Reference No:	<b>2024/62/92044/E</b>
Site Address:	Fairleigh House, Penistone Road, Birds Edge, Huddersfield, HD8 8XW
Description:	Erection of detached garage and single storey extension following demolition of existing outbuildings
Recommending Officer:	Nicole Helliwell

**DECISION – Conditional Full Permission**

## **Officer Report**

**Proposal:** Erection of detached garage and single storey extension following demolition of existing outbuildings

TITLE PROPOSED DRAWING
FLOOR PLAN
GROUND FLOOR LEVEL
SCALE 1:50 @ A1

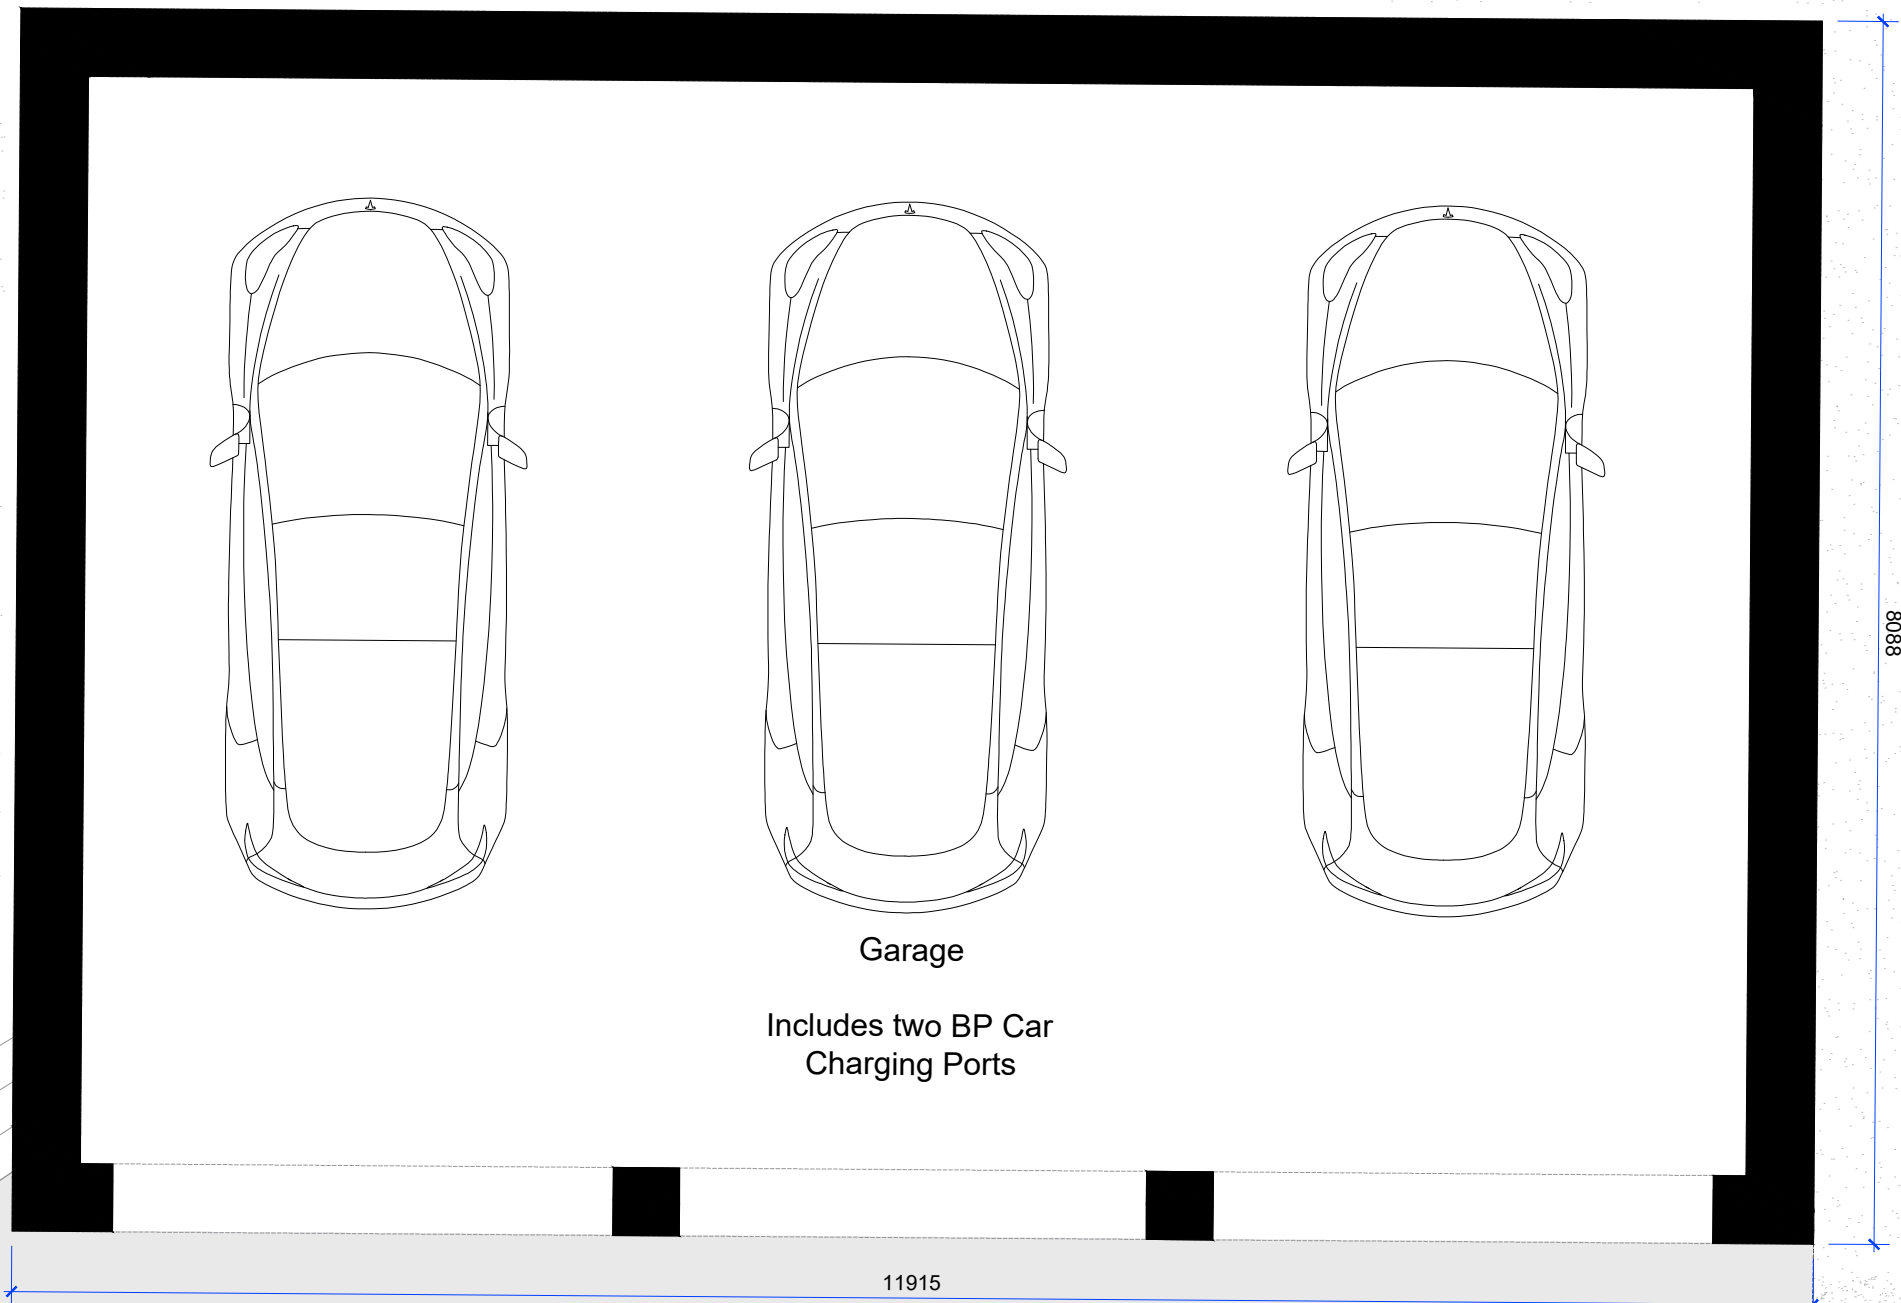
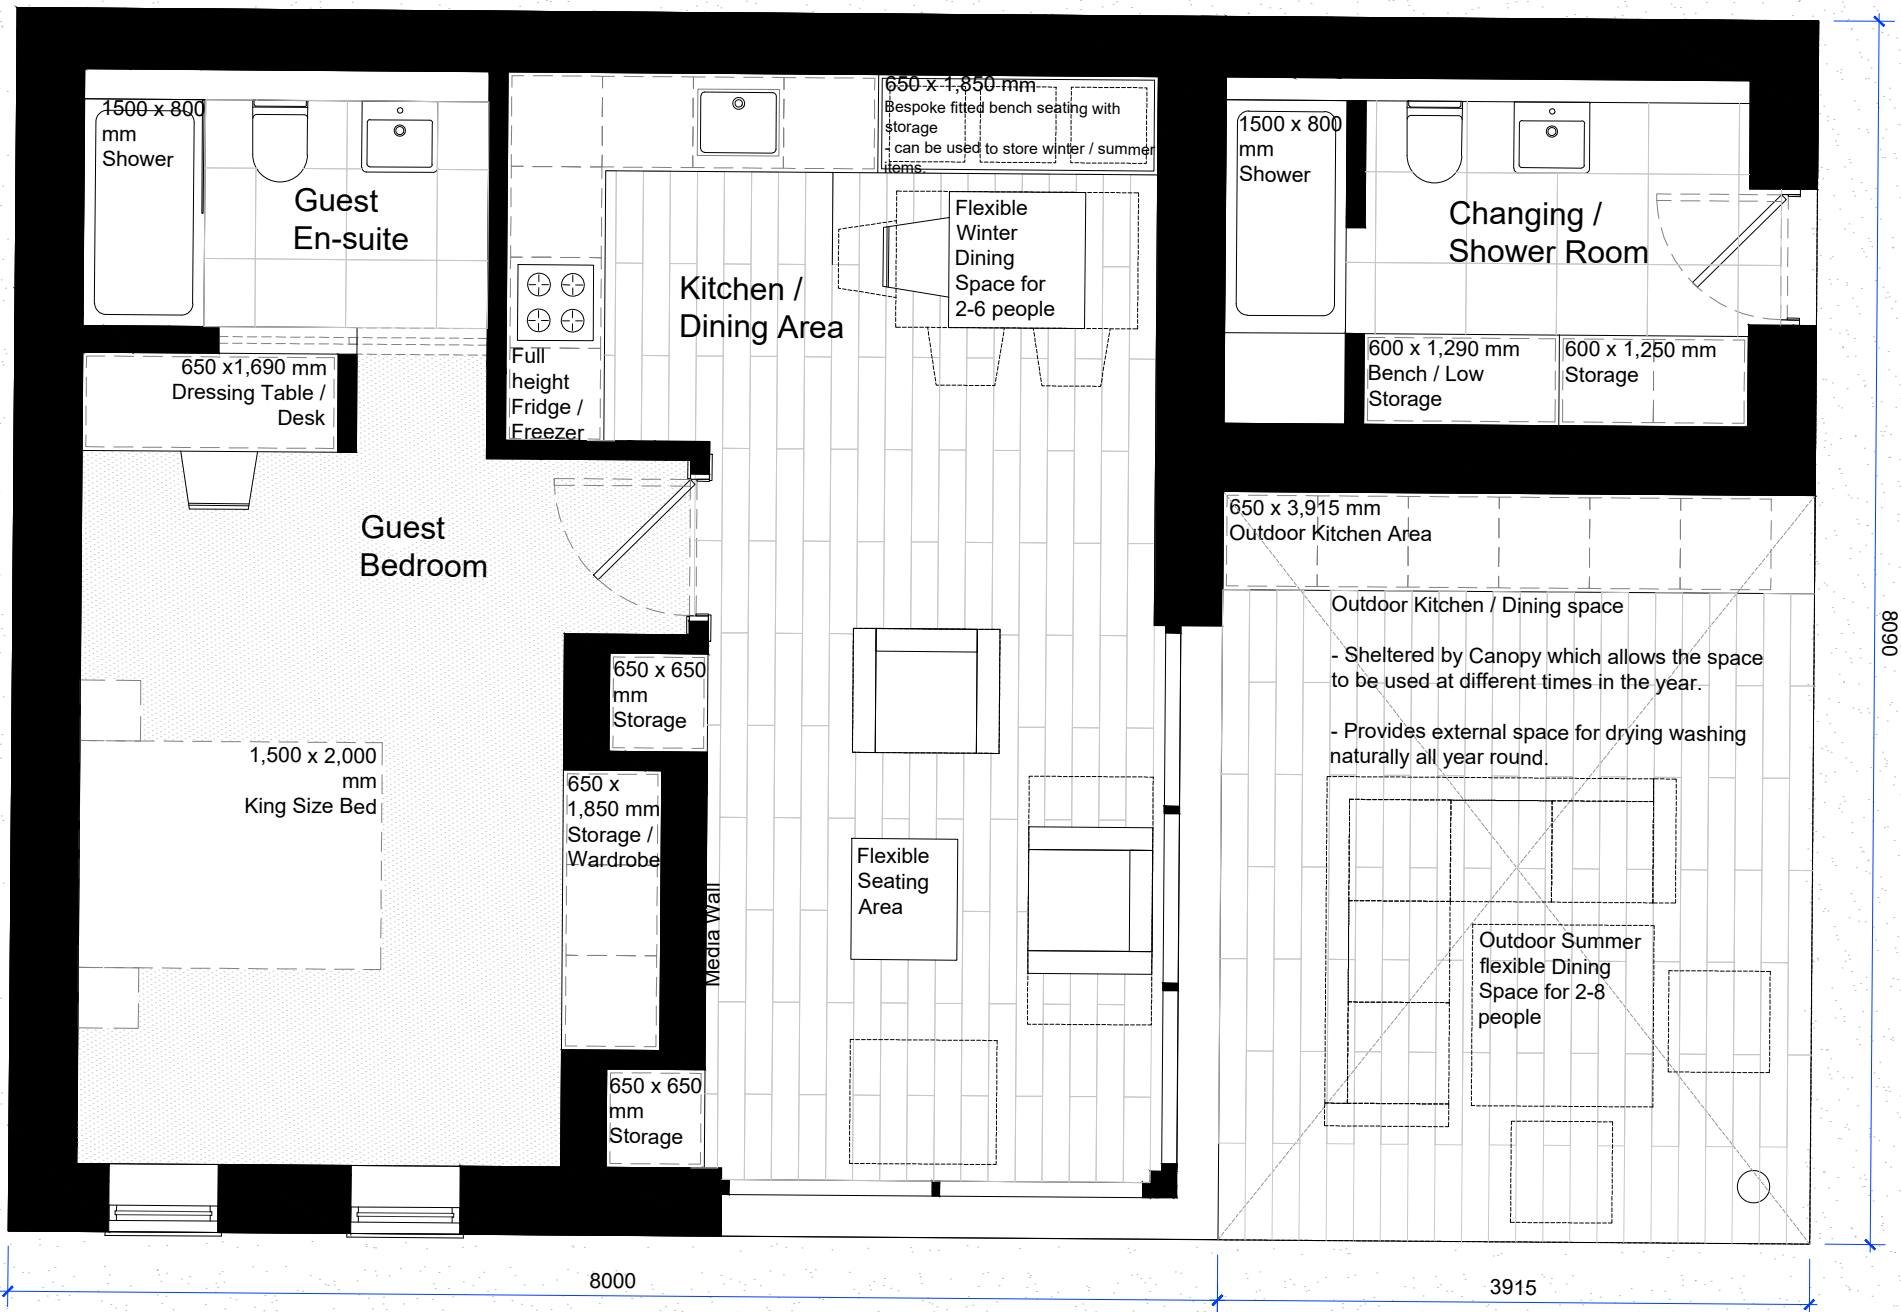
The proposed single storey extension would project approximately 4.48m from the south-western elevation of the original dwellinghouse. The enlargement would be faced in materials to match the appearance of the host property and would incorporate a flat roof form with roof lights. Although this feature would generally constitute poor design, the extension would be concealed by the existing boundary treatments and would have limited visibility from public vantage points. It is also noted that the extension would have a large scale. However, it would be a subservient addition and would maintain a sense of space within the plot. Therefore, it is considered that the proposed development would respect the character and appearance of the host property and wider street scene.

3. The single storey extension hereby approved shall be faced in natural stone for the external walls and flat roof membrane for the roof. The materials of construction shall thereafter be retained for the lifetime of the development.

**TITLE PROPOSED DRAWING  
SITE ELEVATIONS**

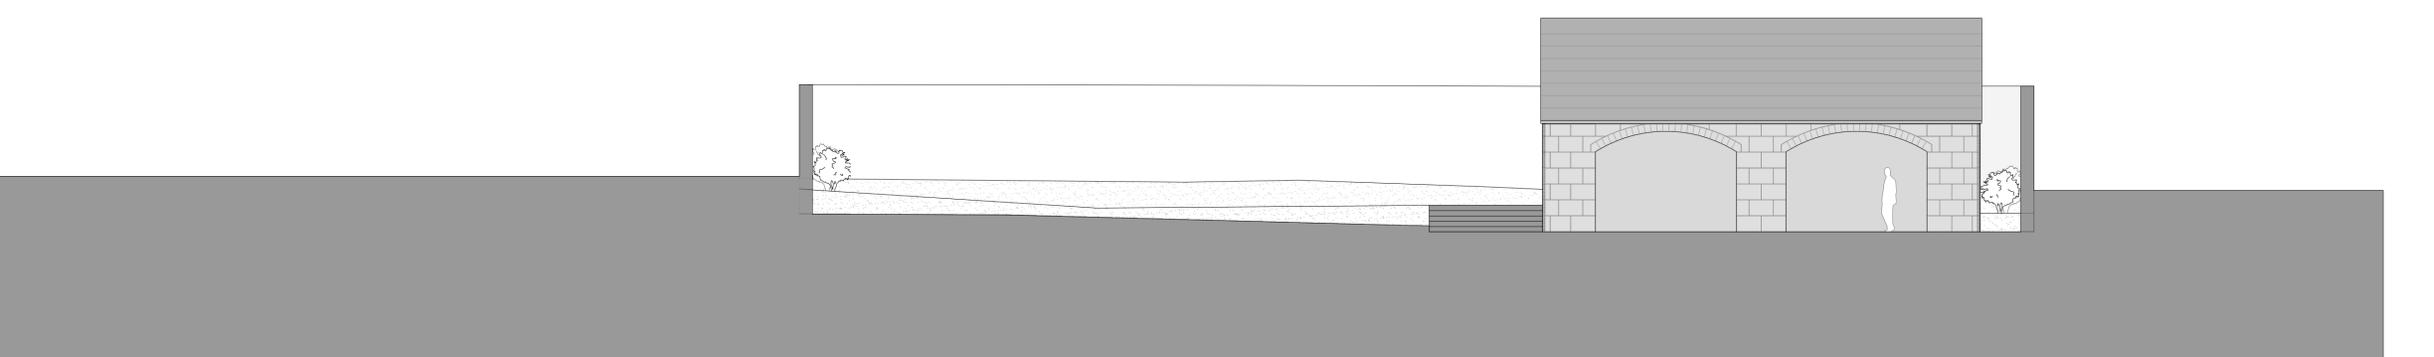
Concerns were raised regarding the development's impact on the Green Belt and visual amenity. The cumulative impact of the proposed extension, detached garage and the annex building was considered disproportionately large in relation to the original building and as such, would represent inappropriate development, which is harmful to the Green Belt and the visual amenity of the area. Amendments were received which omitted the annex building from the application. Officers deemed that the alterations made were acceptable and it was considered that no further publicity was required.

Denby Dale Parish Council – No objections however concerns were expressed over the size of the annex

The application seeks planning permission for the erection of a detached garage and a single storey extension. The proposal originally included an annex building, however this has since been removed following negotiations with the applicant's agent. It is considered that the proposed additions would be subservient and would have an acceptable scale relative to the original dwellinghouse. Furthermore, given the size of the host property and its associated curtilage, it is considered that the effect on the Green Belt would be minimal. It is therefore considered that the impact of the proposals on the openness of the Green Belt, both spatially and visually, would be acceptable. On this basis, it is considered that the proposed development would preserve openness and would constitute an acceptable form of development in the Green Belt in accordance with Policy LP57 of the Kirklees Local Plan and the guidance contained within Chapter 13 of the NPPF.

The detached garage would be located within the rear curtilage of the dwellinghouse and would have a length approx. 12.4m, depth approx. 8m and an overall height approx. 6.05m. The structure would be faced in natural stone and would incorporate a dual pitched roof finished in natural slate to match the appearance of the original build. Although the structure would have a large scale, it would be concealed to a certain degree by the existing boundary treatments and would appear subservient in relation to the original dwellinghouse. For these reasons, the proposed development is not considered to have any significant visual impact on the character and appearance of the host property and surrounding area and therefore would be acceptable in this regard.

***Officer comment:** The annex has since been omitted from the planning application.*
